CITY OF ALBUQUERQUE

February 9, 2024

**RE: Rio Grande Apartments
2211 Rio Grande Blvd. NW
Grading and Drainage Plans
Engineer's Stamp Date: 01/22/24
Hydrology File: H12D024**

HYDROLOGY PLAN

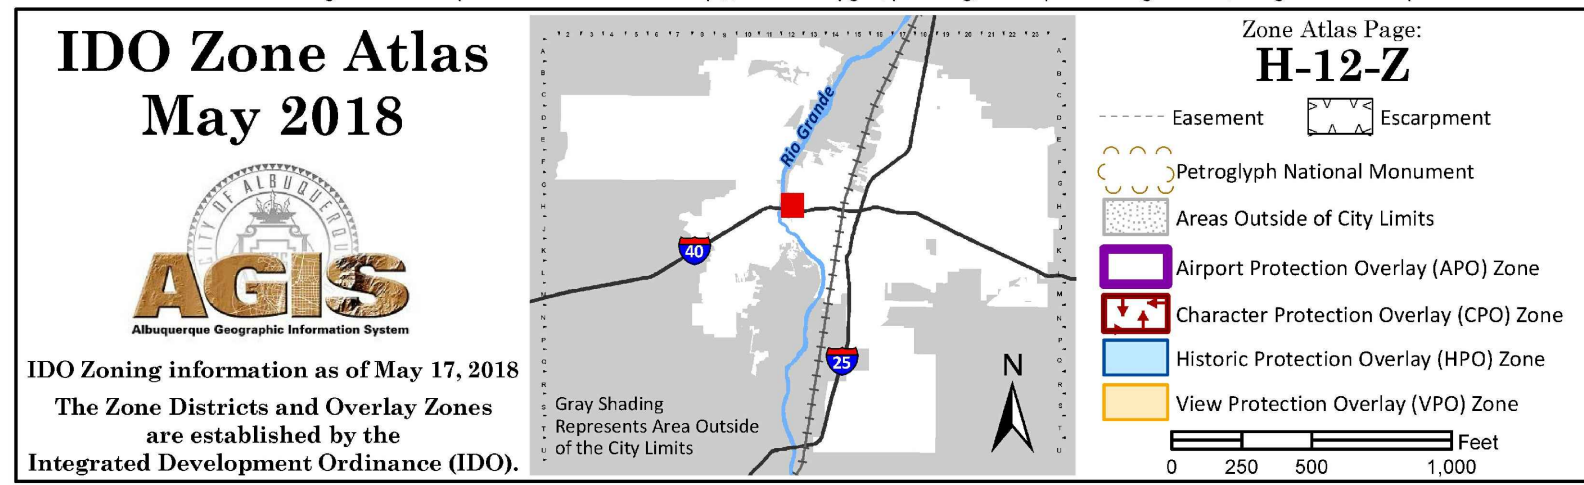
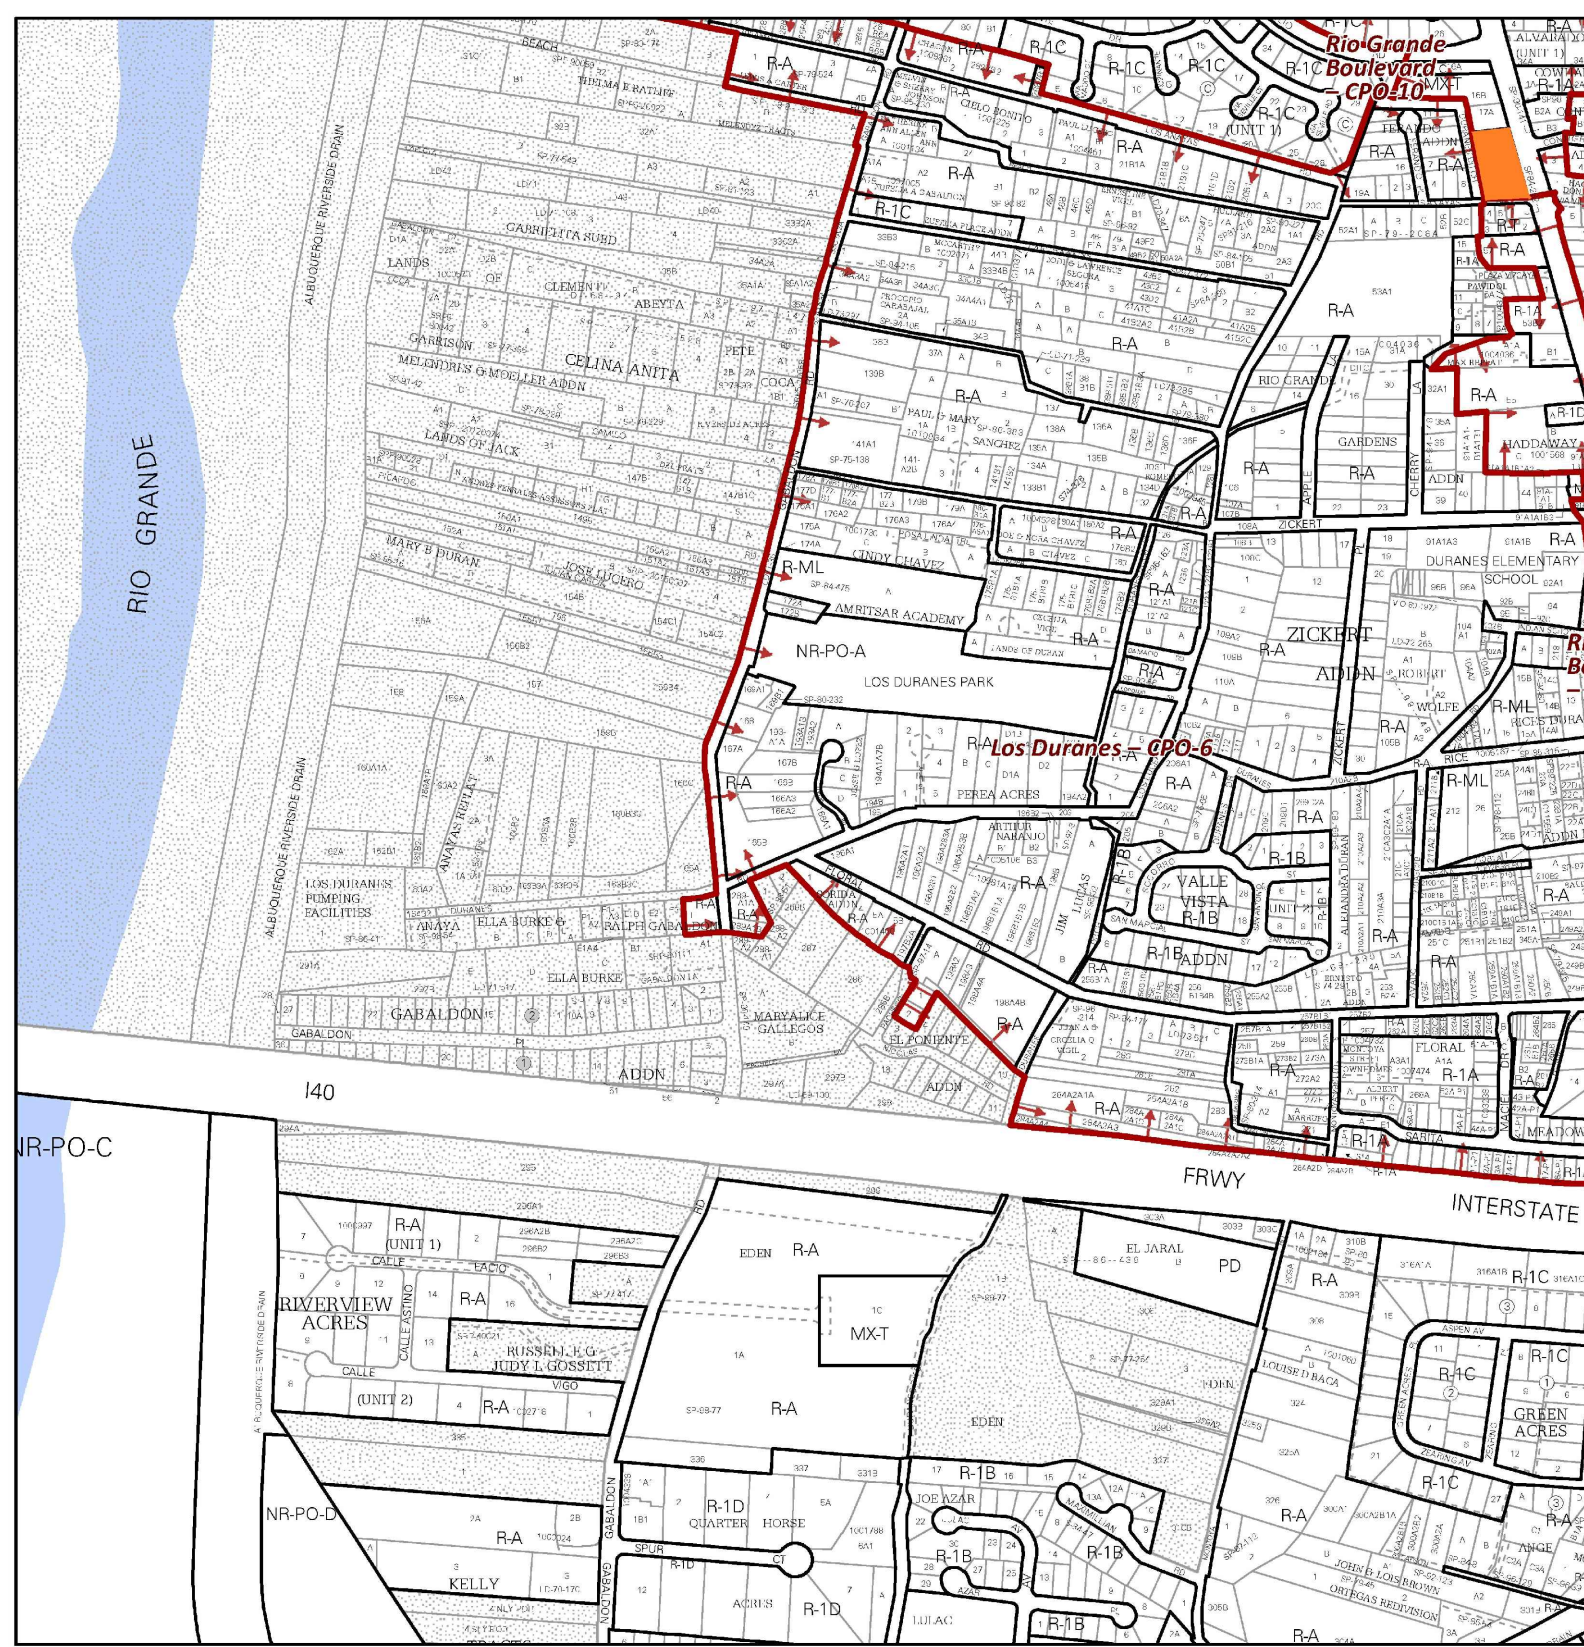
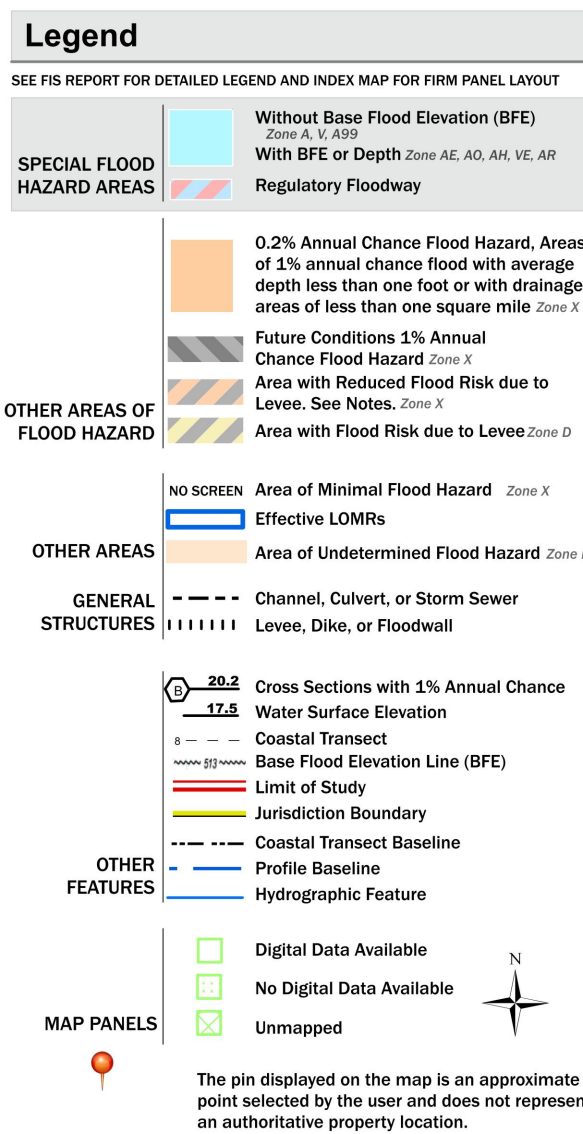
SHEET C-101

1. Please provide a legal Description of the property.
2. Existing Conditions. This site is in FEMA's Zone X Protected by Levee. (please fix note #9 of the General Notes as well) Also, the site is relatively flat and does not drain. There are also no railroad tracks anywhere near this site. Please fix the Existing Conditions.

3. Proposed Conditions. Please remove all references to the County and change it to the City.
4. Please change the wordage of the water harvest ponds to retention ponds. Water harvest ponds are typically stormwater quality ponds.
5. Please provide the weir calculations, per DPM Article 6-16(A), for the curb cuts and sidewalk culverts. A coefficient of 2.7 is typically used for the weir equation $Q = CLH^{2/3}$.

A1 CONCEPTUAL SITE GRADING AND DRAINAGE PLAN
SCALE: 1"=20'

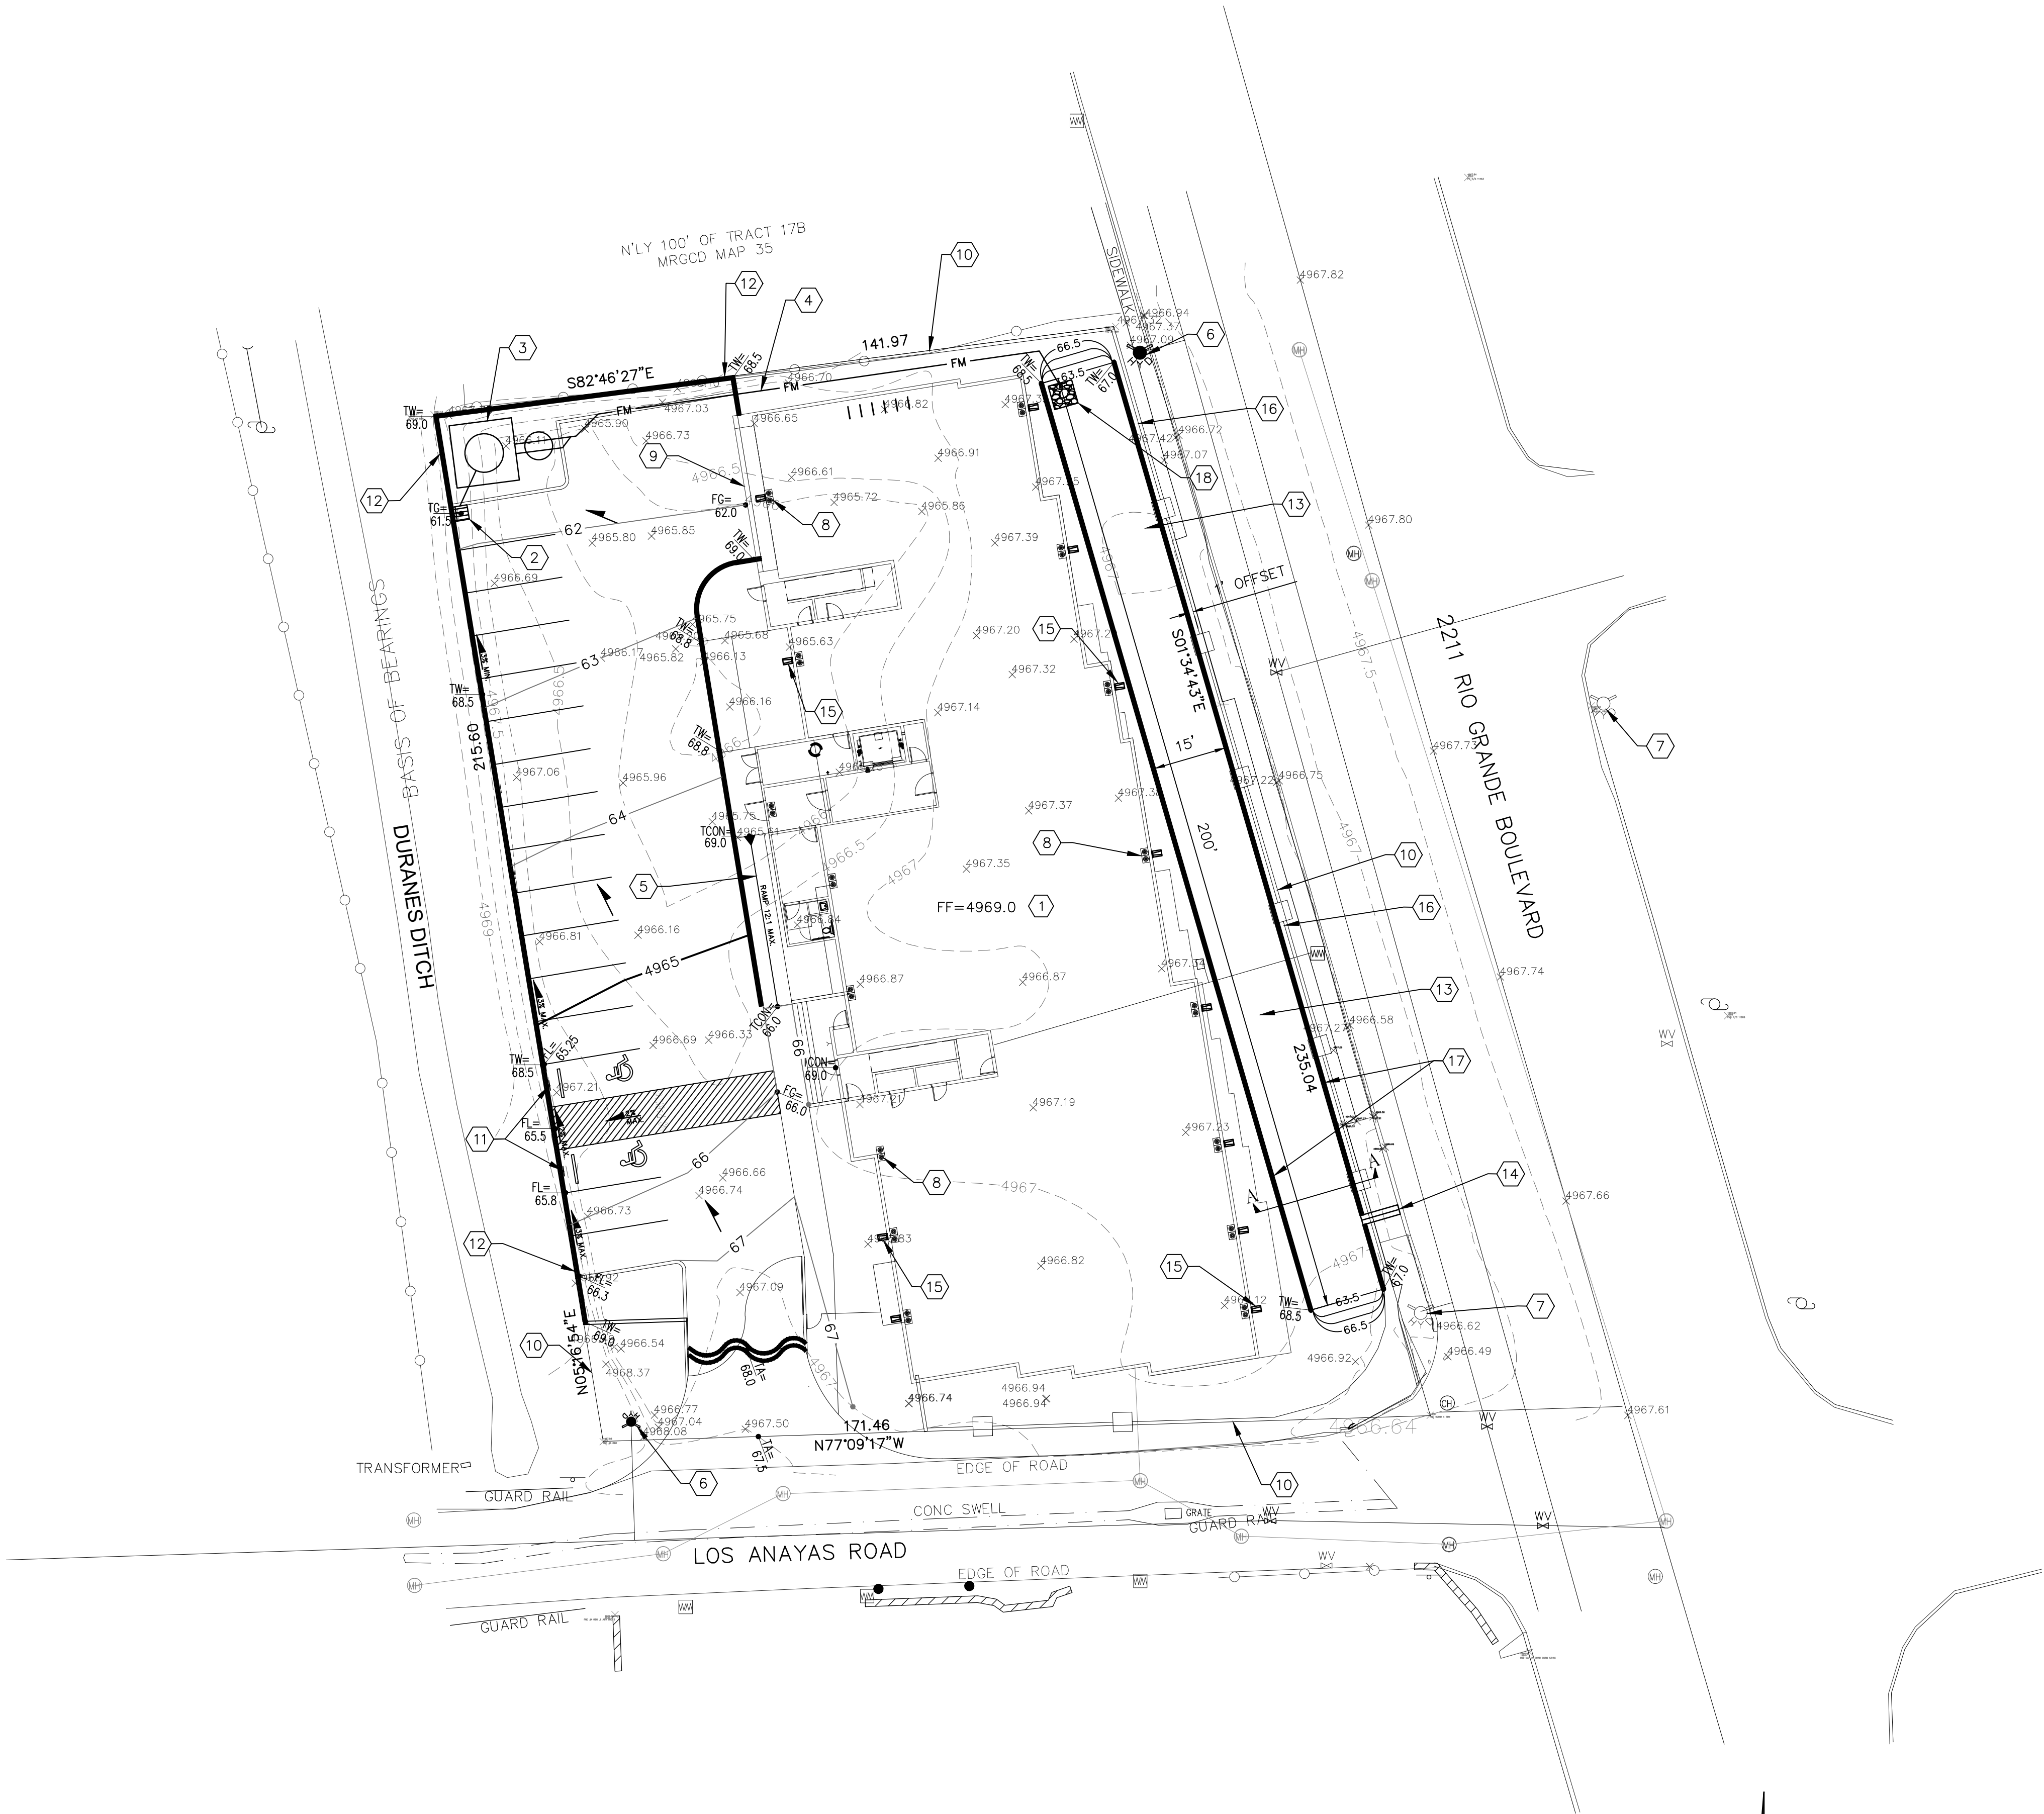
SHEET C-102

6. It is difficult to tell what is being installed since all the line work both existing and proposed is the same. Please change. Also the edge of roadway on Los Anayas Rd should only be a single line since there is no curb & gutter.

7. Please verify with Transportation. Along Los Anayas Road, this project will be responsible to install sidewalk along with curb & Gutter per the IDO.

8. Please remove Conceptual for the title of the Grading Plan.
9. Please provide a cross section for the retaining wall along the west property line showing proposed retaining walls, property/ROW lines, existing and proposed grades. In accordance with DPM, grading and wall construction near the property line may not endanger adjacent property or constrain its use. Please make sure that the footer for the wall stays within the project's property. Please provide this section on this Sheet.

10. Please move the cross section of the retention pond from Sheet C-501 to this Sheet. Also please refer to comments under Sheet C-501 for corrections to this cross section.

11. Key Note 8 should refer to City of Albuquerque standard detail No. 2236 – Sidewalk Culvert with Steel Plate Top.
12. Please provide invert information for the sidewalk culvert both at the retention pond and at the curb.

13. Please identify all underground utilities shown within the streets.
